Development Control  
Ribble Valley Borough Council

**Re:** Planning Application 19/0465

**Address:** Field off Lower Road Dutton PR3 2YL

**Description:** Erection of sheep shed with access tracks from existing vehicular accesses

Drawing Title
 plans elevations
 AS PROPOSED

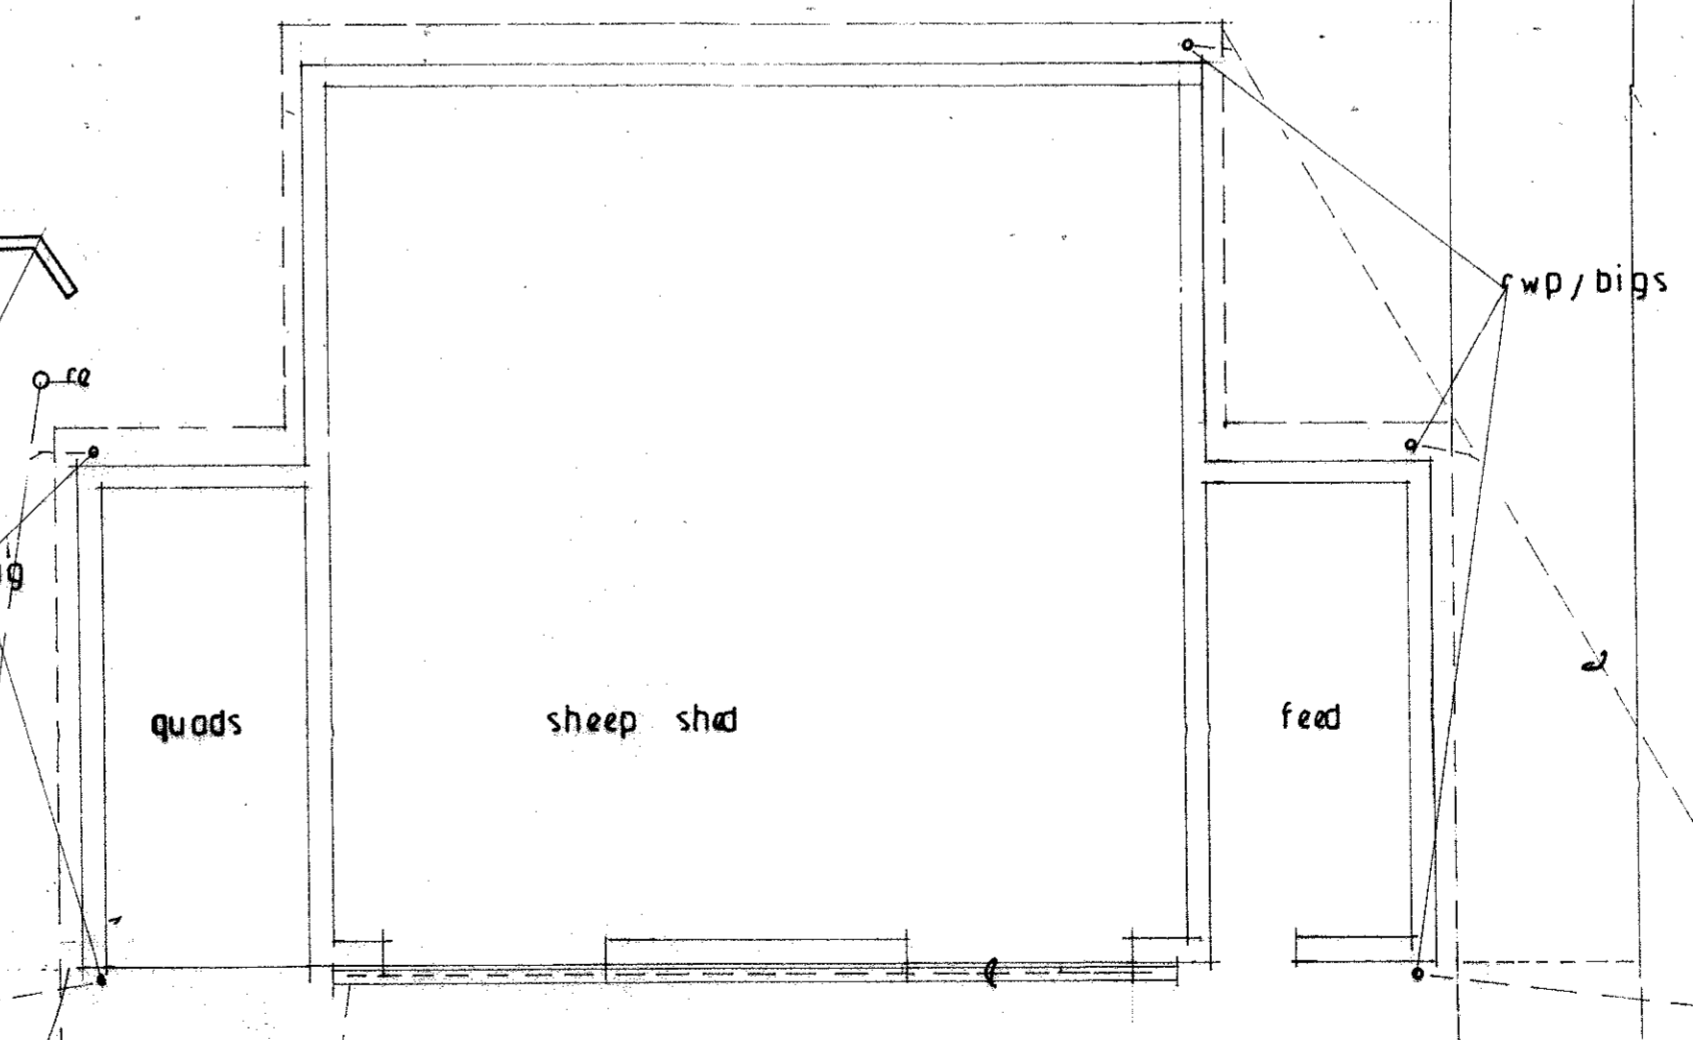
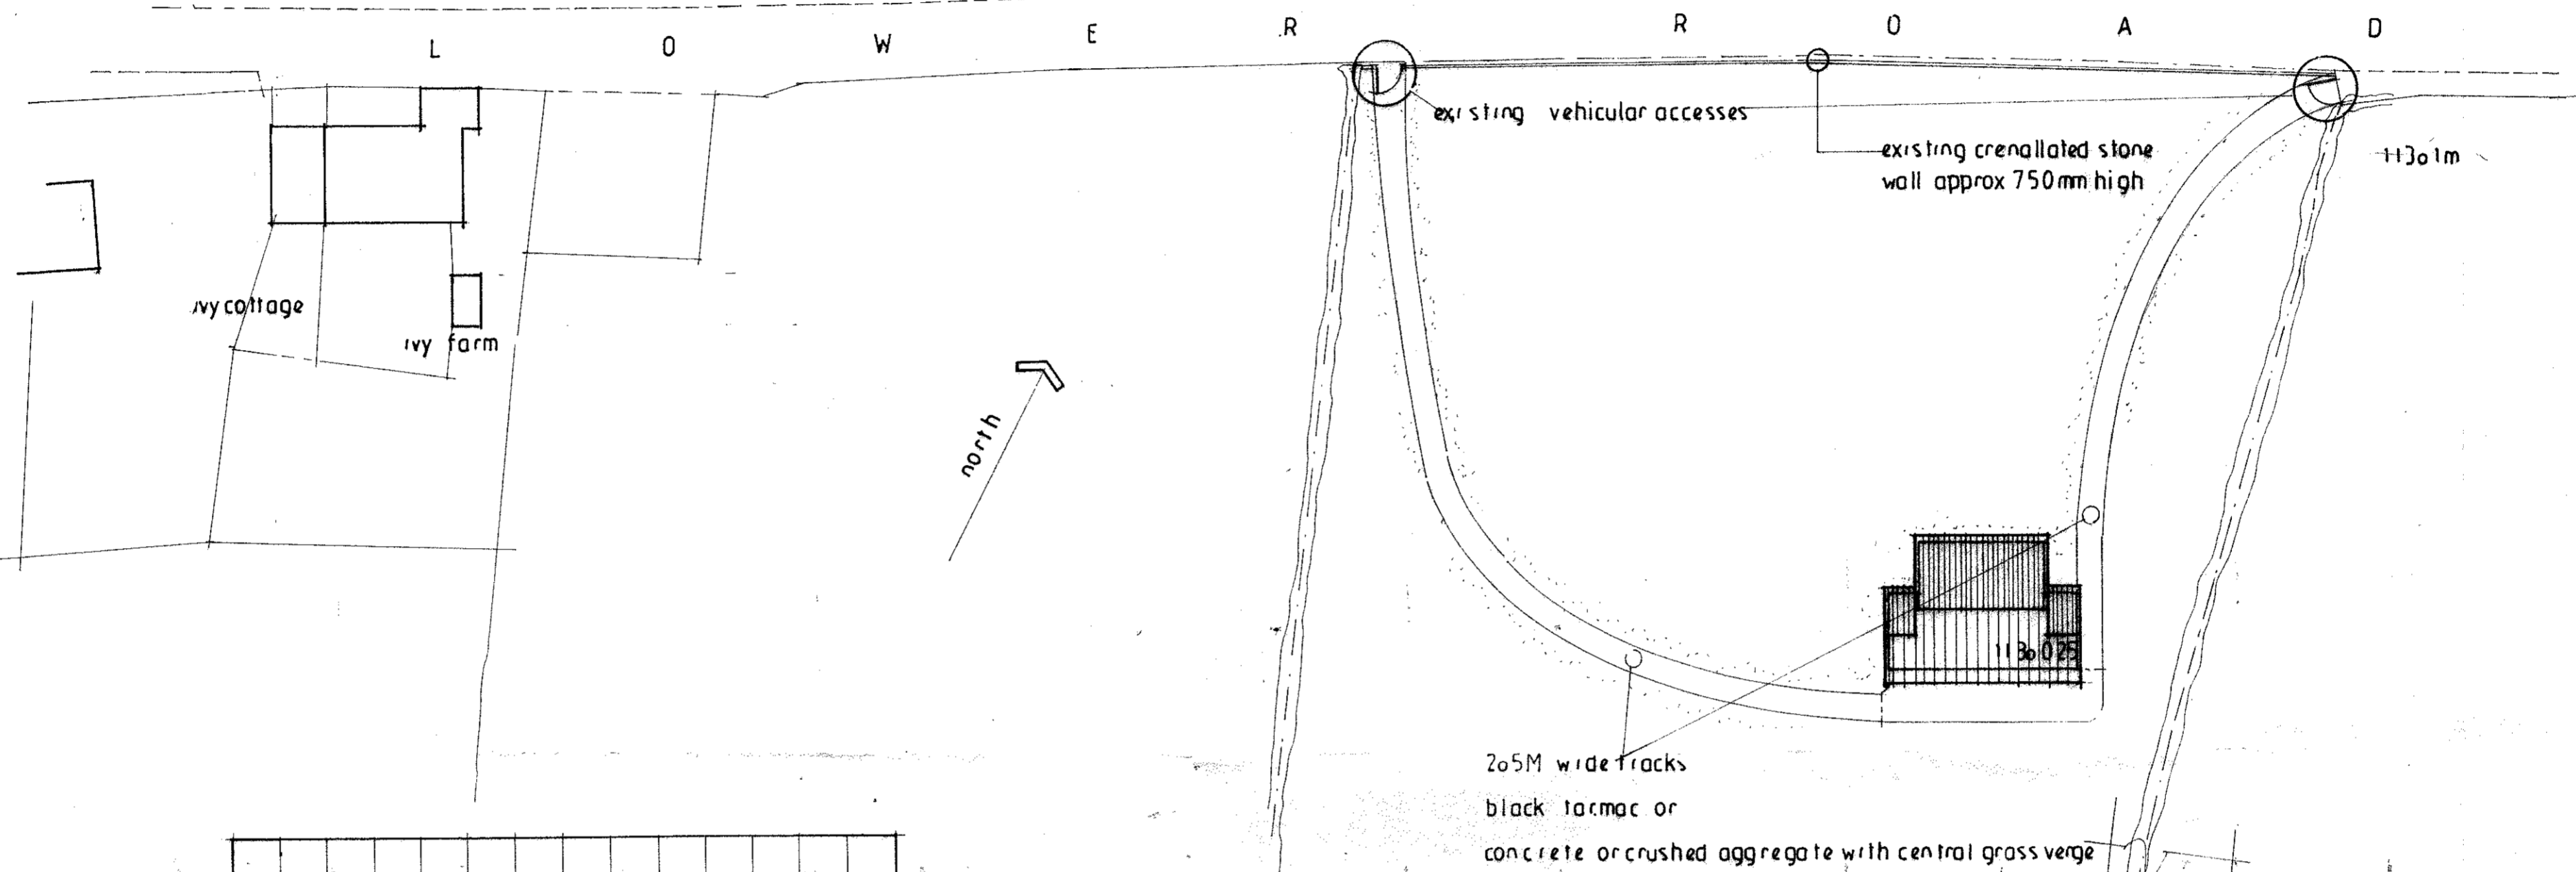
This application is seen as an intensification of the use of the site using either of two existing accesses neither of which are suitable for an intensified use.

Lower Road, Dutton is a classified road (B6243) which is subject to the national speed limit being 60mph. There has been a traffic count carried out within the vicinity which shows that the actual speed of the traffic in the area is lower and a speed of 50 mph can be used to obtain a visibility splay of 2.4m x 148m in either direction this should be free of visual obstruction such as trees, walls and bushes over 1m in height.

- A plan will be required showing the visibility splay that can be obtained
- A new single access being formed perpendicular to Lower Road

- Any gates being set back by at least 5m and these shall open away from the highway
- The area from the gates to the highway boundary being formed from a suitable bound surface
- The other gate being removed and the gap being permanently closed
- Any vehicle leaving the site will be required to enter and exit in a forward gear
- The self-seeded trees in the verge adjacent to the site will need to be removed
